Our ref: OUT25/8959

Subject: Boggabri Coal Mine Modification 10 (MP09_0182) – Modification Report

Detailed advice to DPHI Planning & Assessment regarding the Boggabri Coal Mine Modification 10 – Modification Report

Figure 4 | Cumulative drawdown – Alluvium and GDE (Source: AGE, 2022)

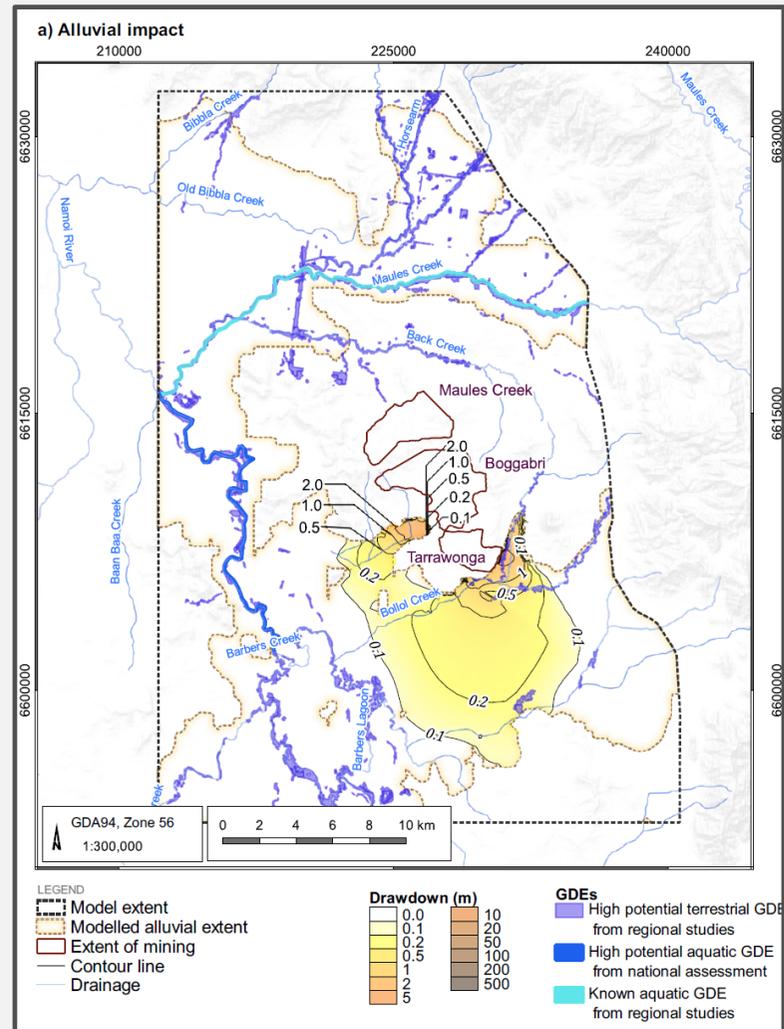
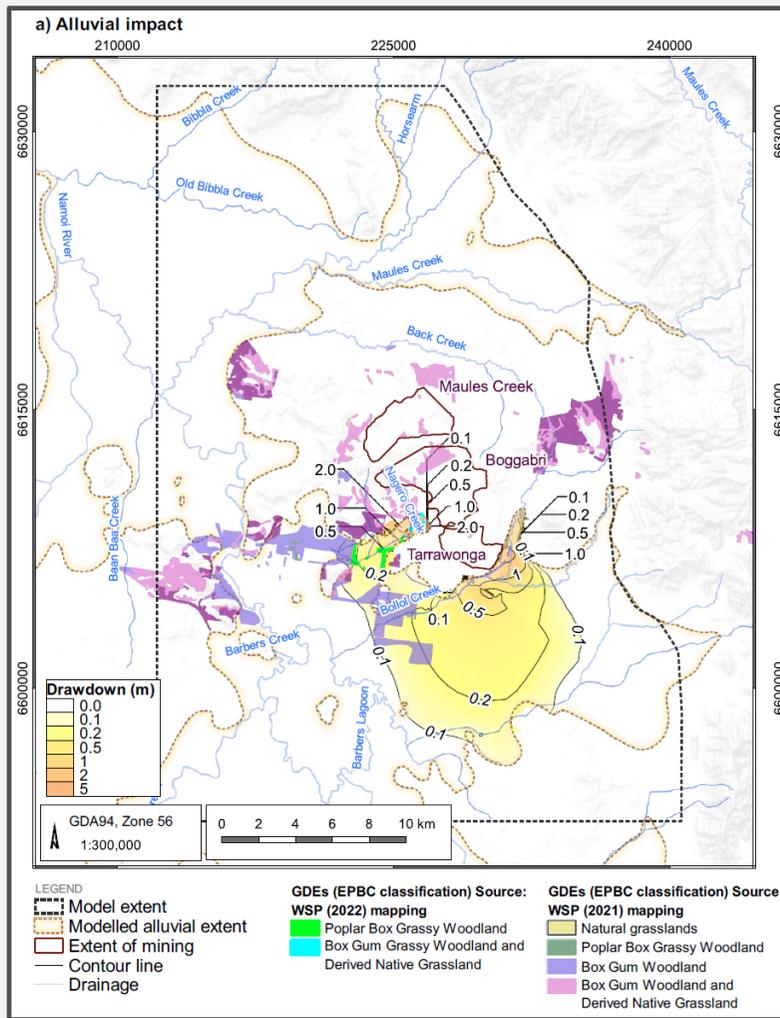
DPHI requests the proponent to provide further detail on the monitoring and Trigger Action and Response Procedure for potential impacts to High Priority Groundwater Dependent Ecosystems (GDEs), including:

- Monitoring of GDEs on Goonbri Creek and Bollol Creek and setting performance criteria.
- A response plan for exceedances of performance criteria, including measures to respond to adverse effects of the mining activities.

High Priority Groundwater Dependent Ecosystems (GDEs) are located along Goonbri Creek and Bollol Creek to the east and south-east of the Boggabri Coal site. Cumulative drawdown at these GDEs is predicted to exceed Level 1 thresholds of a 10% cumulative drawdown under the AIP minimal impact criteria. Although these predictions are consistent with previous approvals, the monitoring and response procedures and the acceptance of responsibility between the relevant mines for each mapped GDE is not clearly defined.

Section 12 of the groundwater impact assessment describes management and mitigation strategies for GDEs to include assessing vegetation survey transects against water level and climate data, and reporting this in the Annual Review. It is noted that there is no clear performance criteria set for GDEs or direct mitigation actions should criteria be exceeded. There is also no reference to monitoring sites of the high priority mapped GDEs along Goonbri Creek and Bollol Creek.
